Application No: EP/124/20/HH
Site Address: Little Dormers 23 Upper Drive East Preston BN16 1QN
Description of works: New bay and porch skirt roof to the front elevation, and roof linked detached double garage.

Thank you for your internet representation made on 17th November 2020 which has been recorded as an objection with the comments as follows:

Garage Plans and Elevations -
Proposed

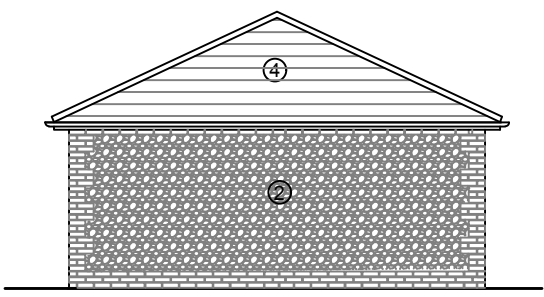
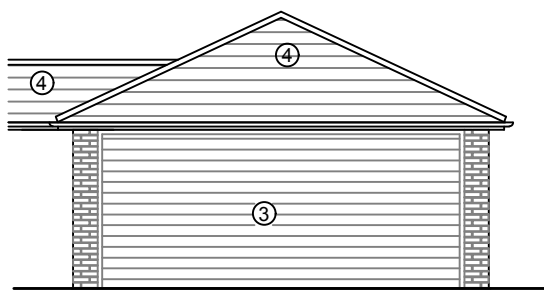
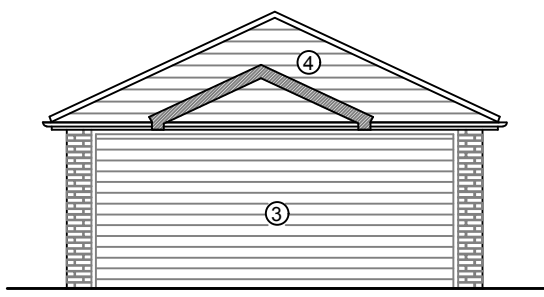
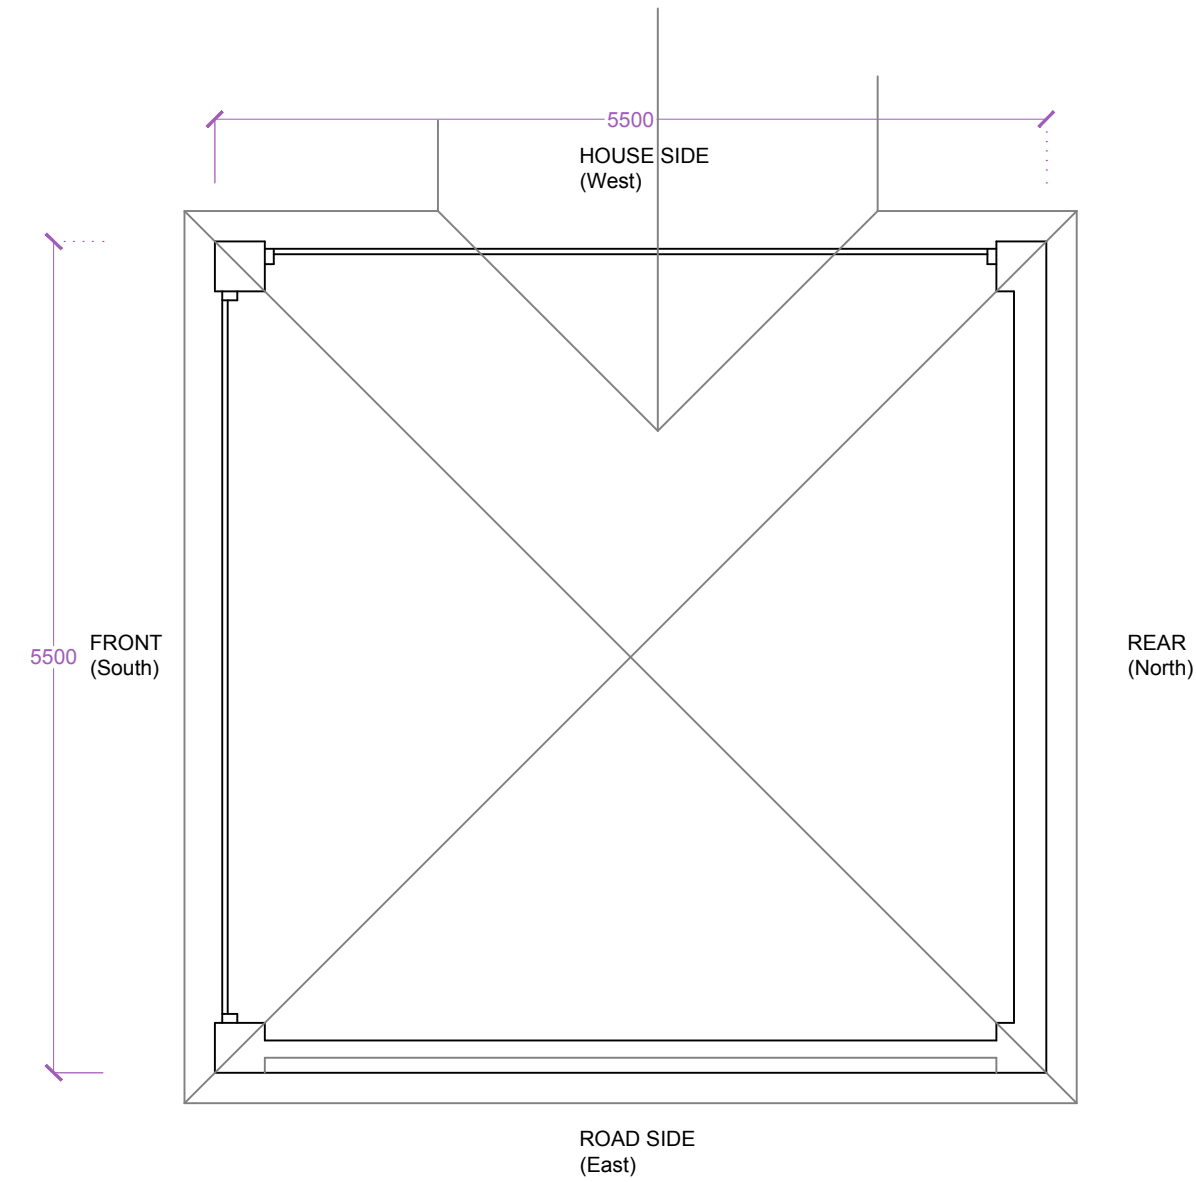
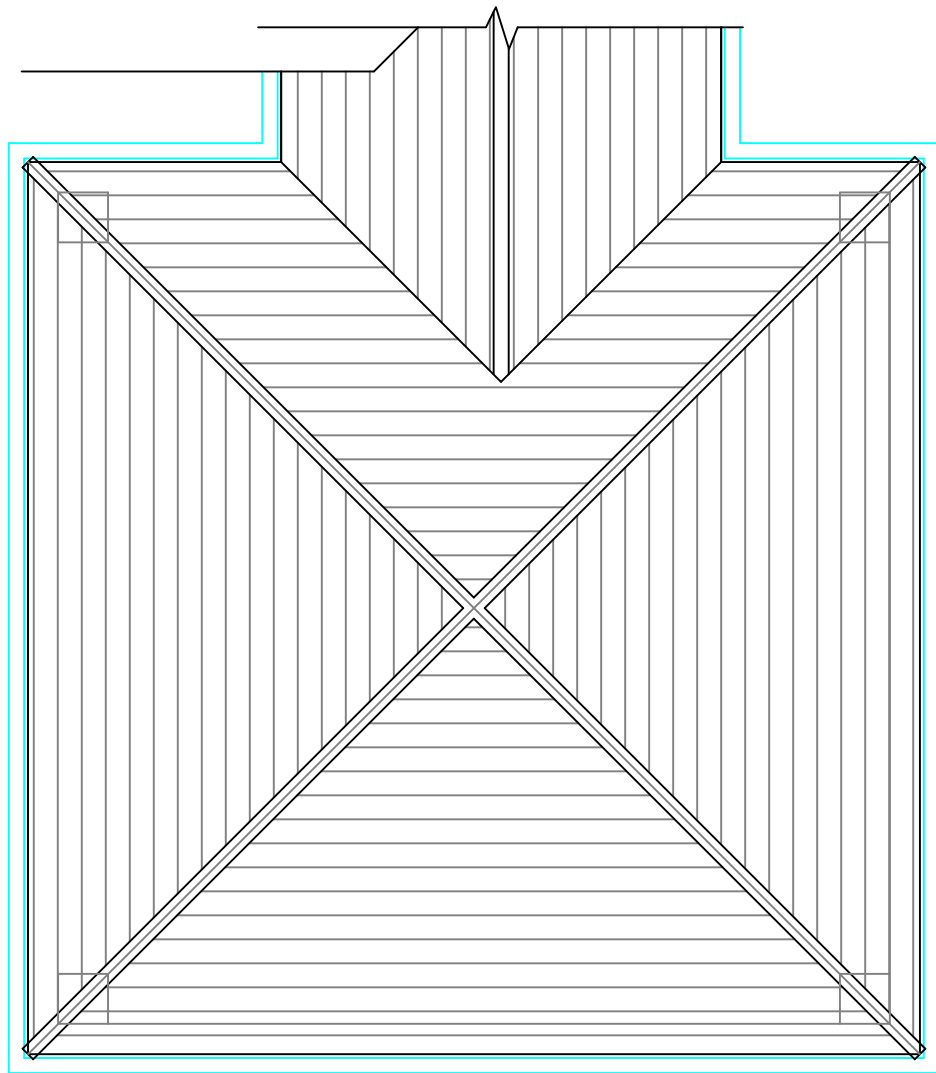
There is little change in the proposed double garage from the original application, Ref. No. EP/96/20/HH.

The proposed double garage to the front aspect of No 23 is, in my opinion, hugely oversized in terms of height, length and width. It is almost half the width of the house in size and half the length. It will extend away from the front of the house eastwards towards the boundary of the curtilage of the property. It appears it would end just before a narrow strip of land, (which is approx. 5 feet wide), owned by the Angmering on Sea Estate, and Upper Drive. This, plus its proposed height, will impact on the view or visual amenity and safety along Upper Drive. It would particularly affect residents living on the west side as well as pedestrians and motorists travelling north and south. Whilst the houses in Upper Drive are all different in design they do conform with a building line. No other property extends eastwards. I feel the proposed size, scale and close proximity of the development would be inescapably dominant, particularly causing a huge loss of light and overshadowing to No 25 to the north, and render parts of Upper Drive an unpleasant place to live.
